**From:** Carol Reynolds  
**Sent:** 11 May 2018 08:48  
**To:** Anita Gardner  
**Subject:** Re: FG/48/18/DOC Onslow Caravan Park, Ferring

The following comments have been received from the Environmental Health Officer re discharge of Condition 6 - Construction Management Plan.

The Drainage Engineer has stated relating to Condition 4 Drainage:

DRAINAGE PLAN - PLANNING
CONDITION 4

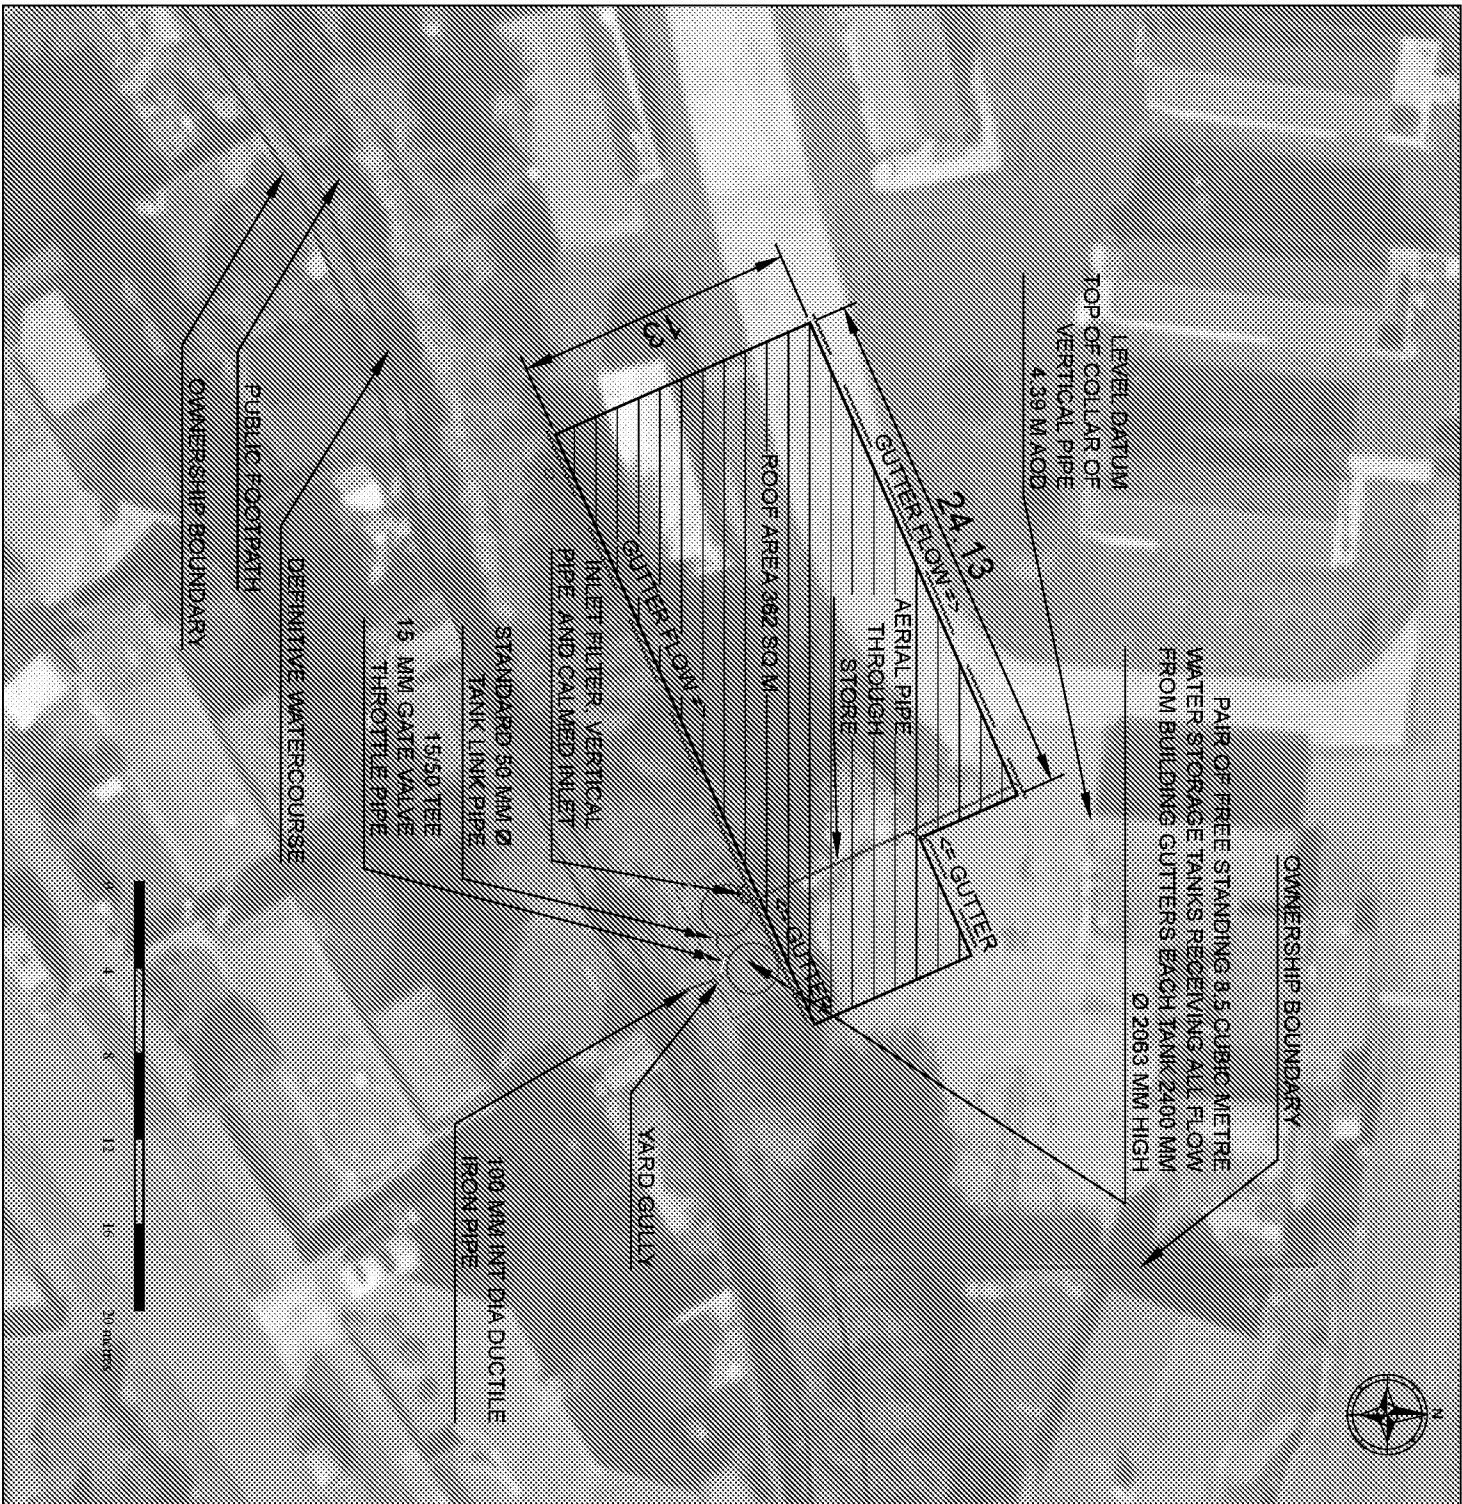
- It is noted that only a 20% allowance for climate change has been included in the design of the surface water drainage system. This needs to be increased to 30% in line with the condition applied.
- Storm durations from and including 15 minutes need to be used.
- The restriction size of 20mm is of concern regarding the possibility of blockage. It is recommended that a mesh or similar is installed within each tank at the face of the outlet.
- It is currently proposed that the outlet to the existing ditch will be formed by a paving slab. This is not acceptable, we require a formal headwall to be formed using concrete bags or brickwork. With full construction detail drawings to be supplied and approved by us.

- Full construction details will be required including the gully/headwall, any manholes, and silt traps. I would therefore appreciate receipt.
